Application No: A/76/15/PL

Recommendation Report for Planning Permission

LOCATION: Angmering Manor
High Street
Angmering

PROPOSAL: Single storey rear extension & re-modelling of front car park area to increase number of spaces from 25 to 32. This application affects the character & appearance of the Angmering Conservation Area.

Title
ADDITIONAL GARDEN BEDROOMS
ELEVATIONS

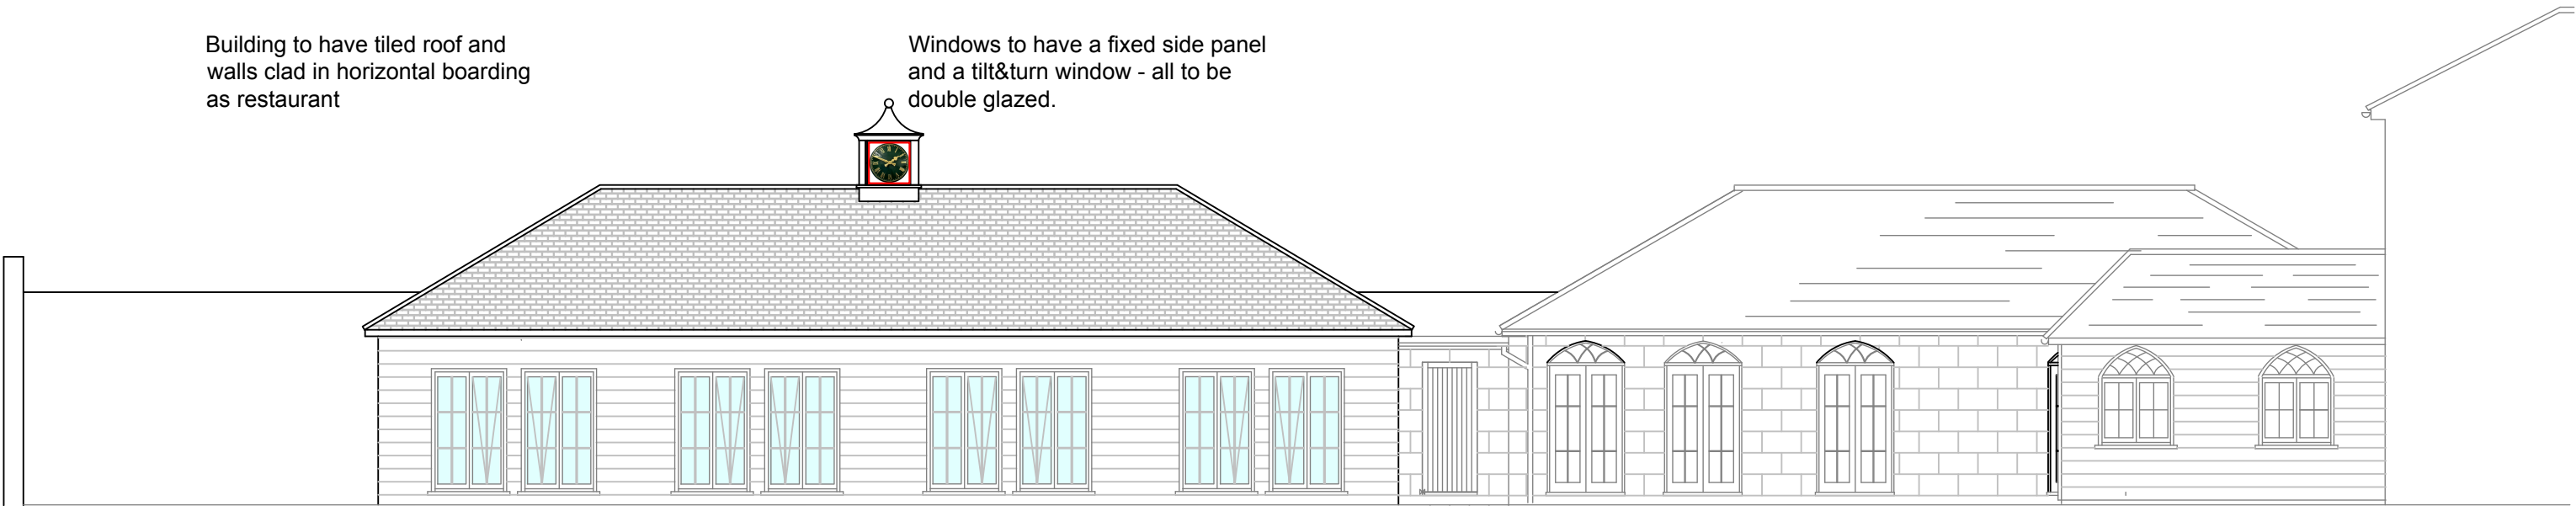
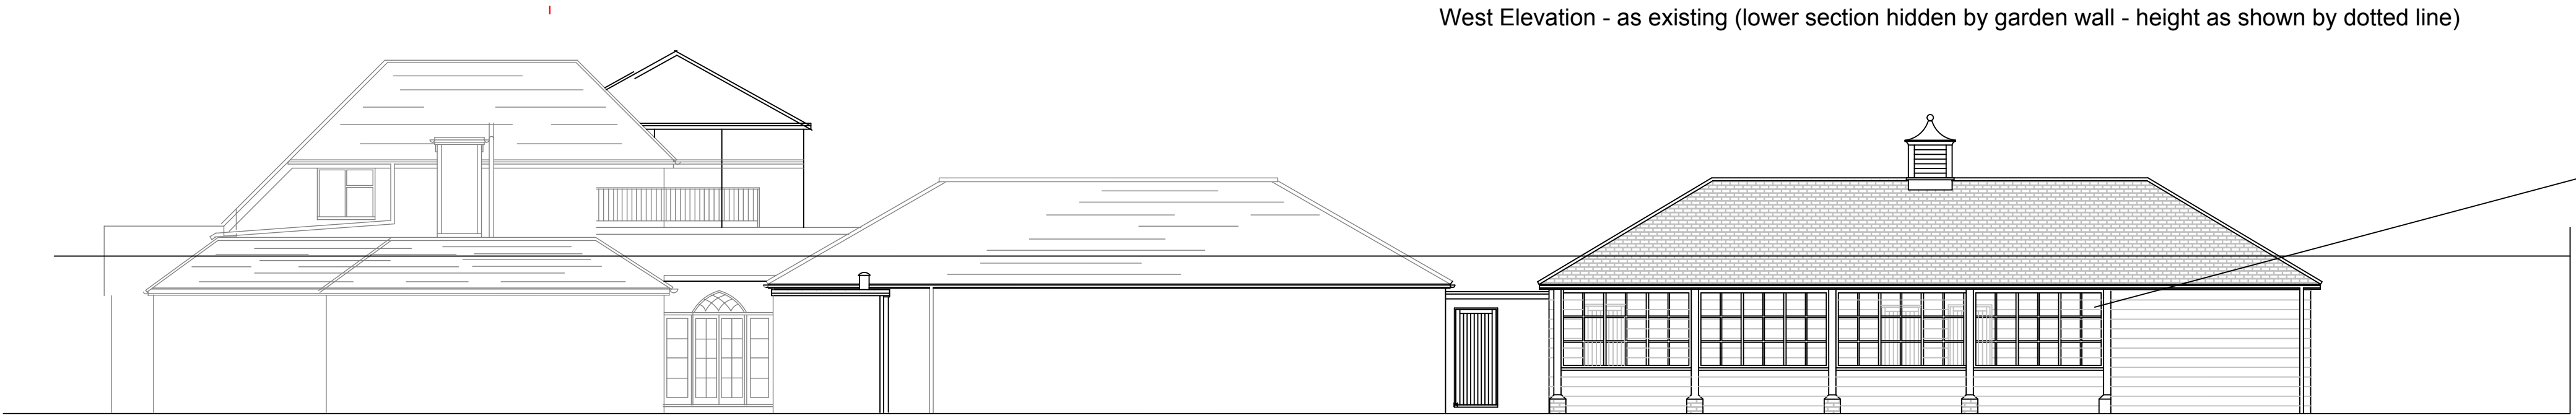
- Door/window details including sections
- Material samples for roof, elevations and guttering
- Detailed drawing of clock tower (please note that this is not shown on the south elevation)
- Planting scheme for the front parking area.

With regard to noise generation, the additional guest rooms would be accessed from the north. A screen is proposed adjacent to the boundary with Garden House and a covered way is included between the swimming pool and the boundary. This would ensure access from the south across the garden is discouraged and that noise generating activity does not take place immediately adjacent to the boundary. A condition is proposed to ensure that the screening is provided prior to use of the rooms to ensure that it is provided as part of the development. Access could be obtained from the garden side of the units which would move activity further from the adjacent garden of 'Garden House'. The screen along the western side of the extension would be sound reducing with infill between the timber panels. It is not considered that the noise associated with the rooms themselves would result in material harm from noise and activity since this would cause a nuisance to other guests if excessive and would therefore be likely to be controlled by the hotel manager.

The re-designed extension to enclose the pedestrian access corridor on the west elevation of the building is acceptable. The previous concern regarding the open nature of this corridor contained within the earlier scheme which was considered to create noise and disturbance to neighbouring properties to the west has been addressed by the enclosed re-design which will avoid significant escape of noise. The intensity of usage would not imply heavy pedestrian movement and the agent has advised that this is a four star hotel where the behaviour of guests is generally very good. Environmental Health have not raised any objections in relation to noise.

Conditions relating to details of the clock tower, materials and door openings are imposed on the listed building consent. The window details were not controlled and have therefore been imposed on this application.

- 9 Before the extension is used the covered way to the west side of the swimming pool and the other sound insulation measures detailed on elevation drawing 1000/13 shall be provided. The measures so approved shall be retained in perpetuity.

Appendix 5 Tree Protection Plan

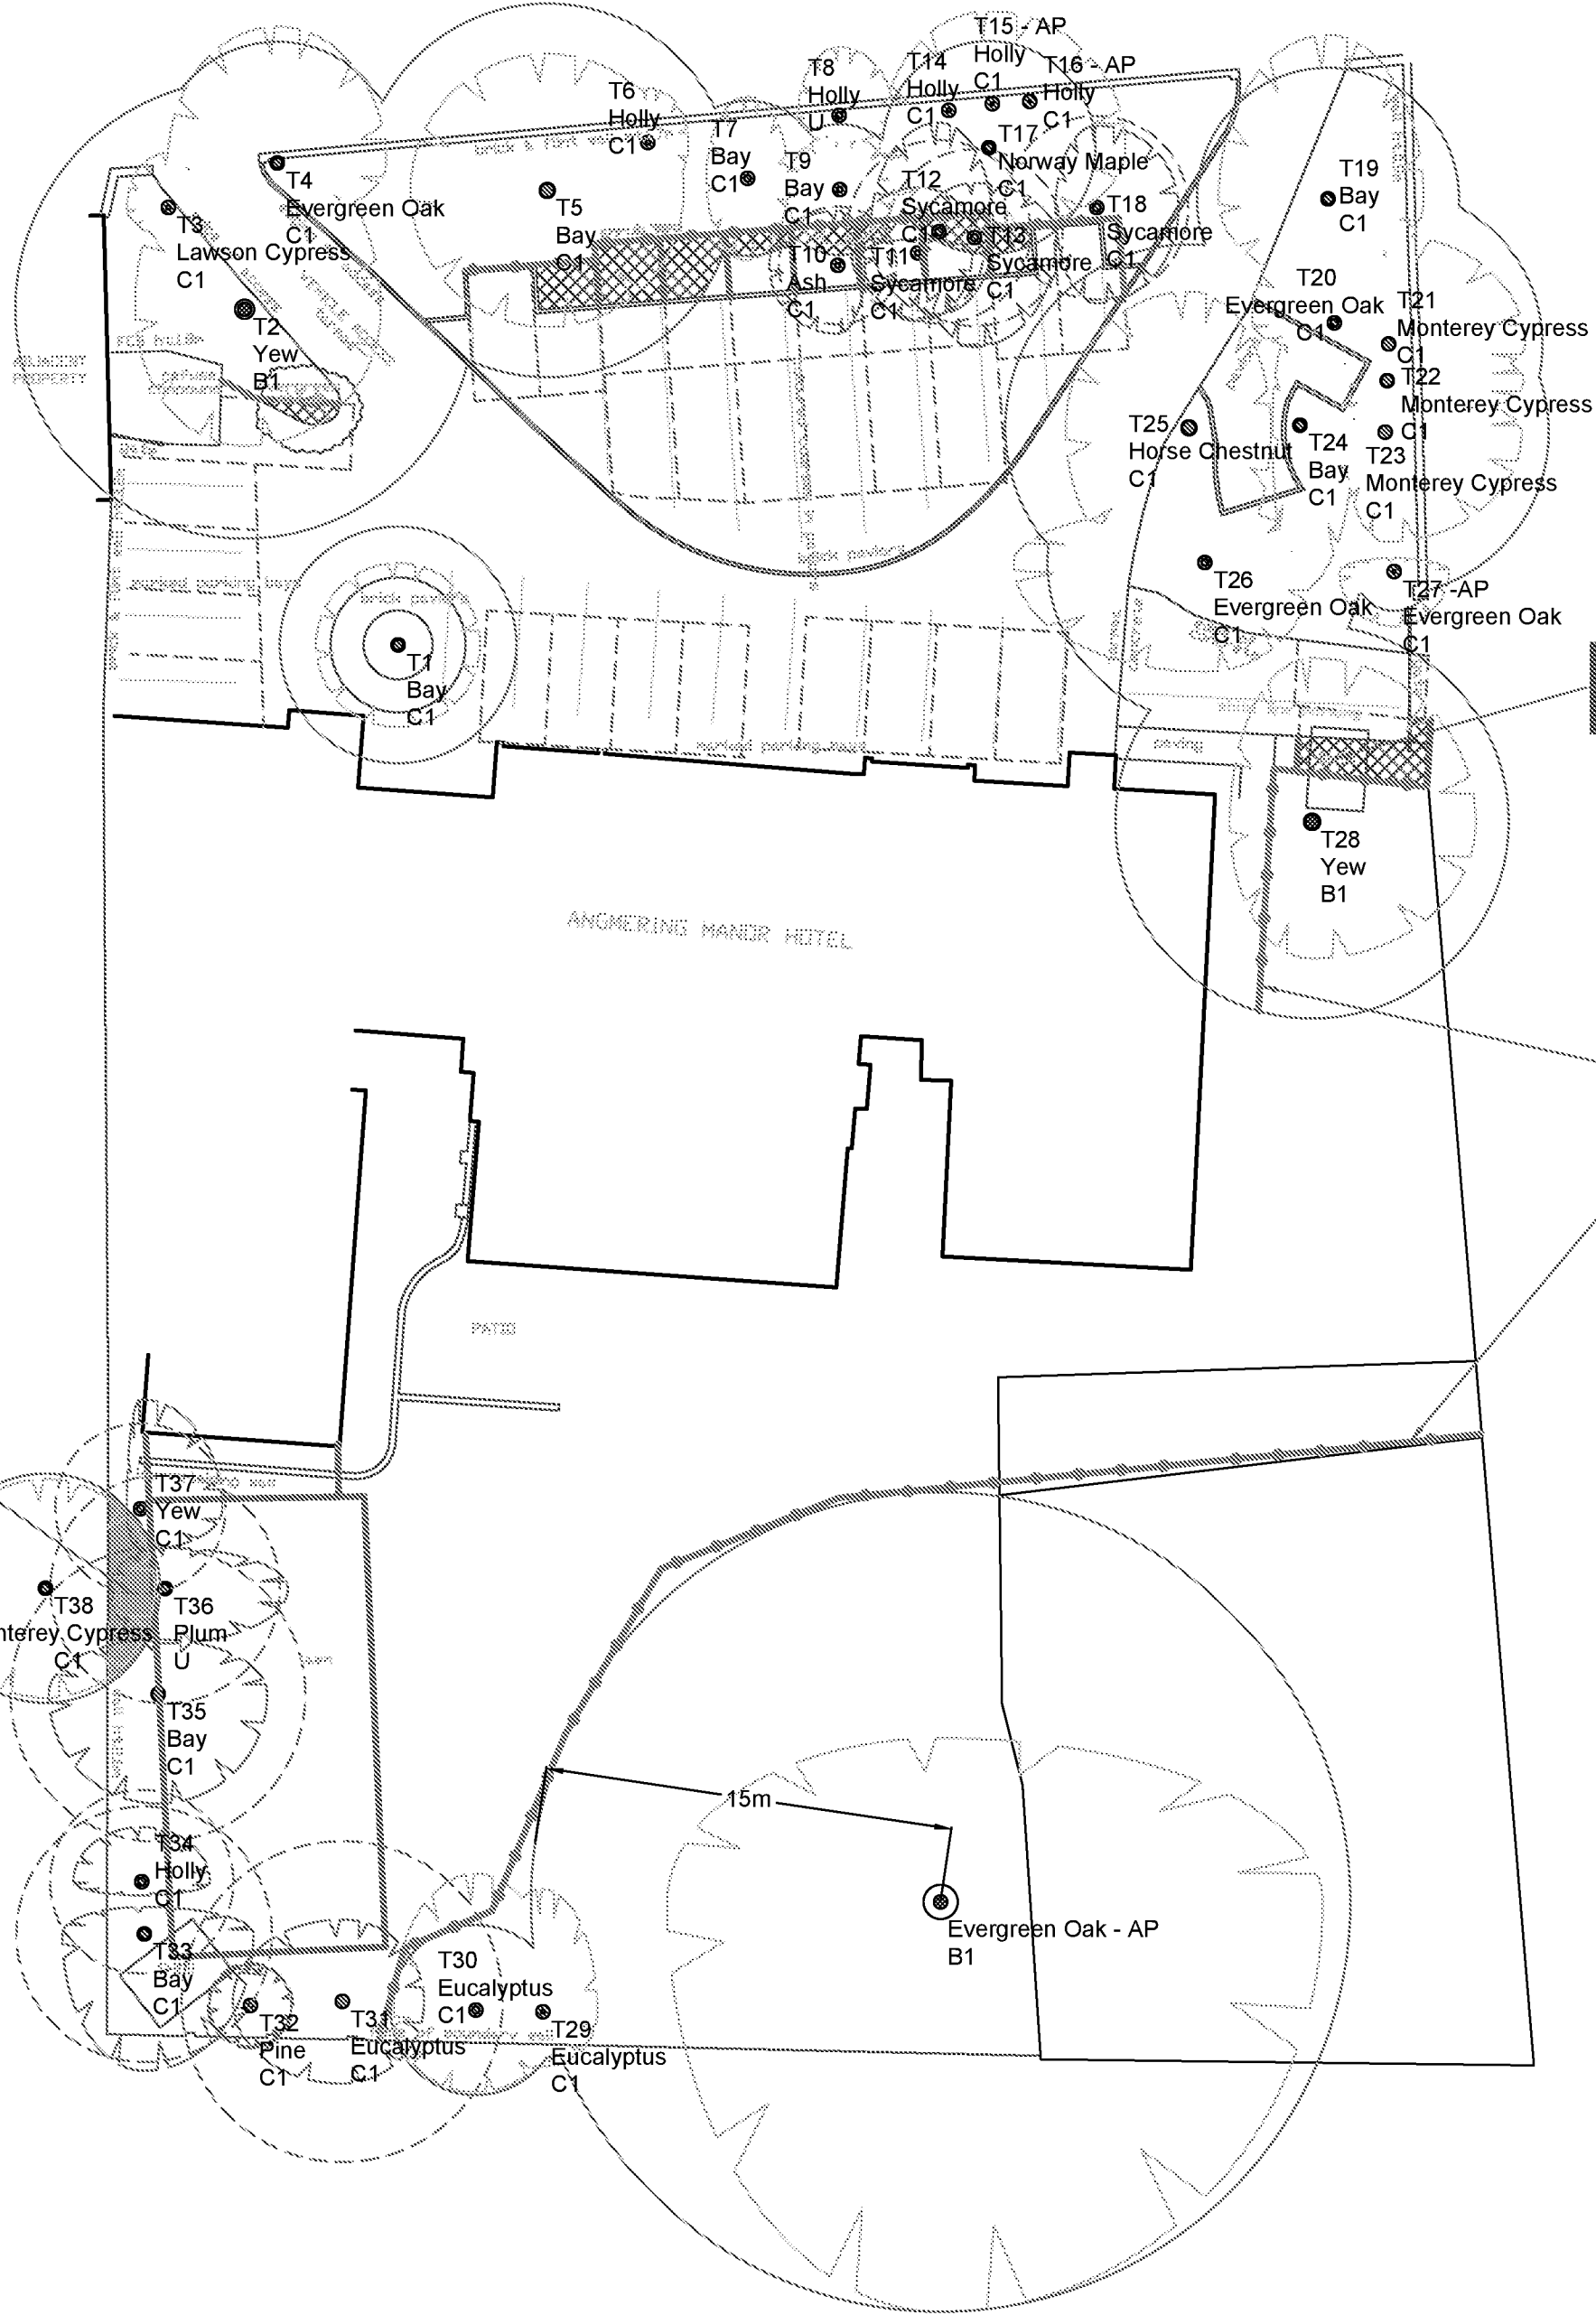
Council's Arboricultural Officer - The applicant has outlined the desire to remove trees. It is clear that the loss of these trees would have a significant impact on the landscape. None of the trees to be removed would warrant protection by a preservation order. The loss of the cited trees would require mitigation replanting, so as to protect the character of the area. This should be controlled by condition

The re-organisation of the parking at the front of the site necessitates the removal of a number of smaller trees and one evergreen shrub. The loss is regrettable, but with supplementary planting the retention of this important verdant part of the Conservation Area can be retained. The loss of the trees identified on both the proposed car park layout plan and within a plan contained within the Arboricultural Report have been considered by the Council's Arborist. He has advised that none of these trees are of individual importance and their removal would not significantly alter or denude the street scene of dominant soft landscaping provided additional replacement planting is controlled and provided by condition.

- 5 No development shall take place on the site unless and until the protective fencing detailed on drawing TPP 15/956 001 has been provided and the siting agreed by the Local Planning Authority's arboricultural officer and the fencing must be retained throughout the course of the development.
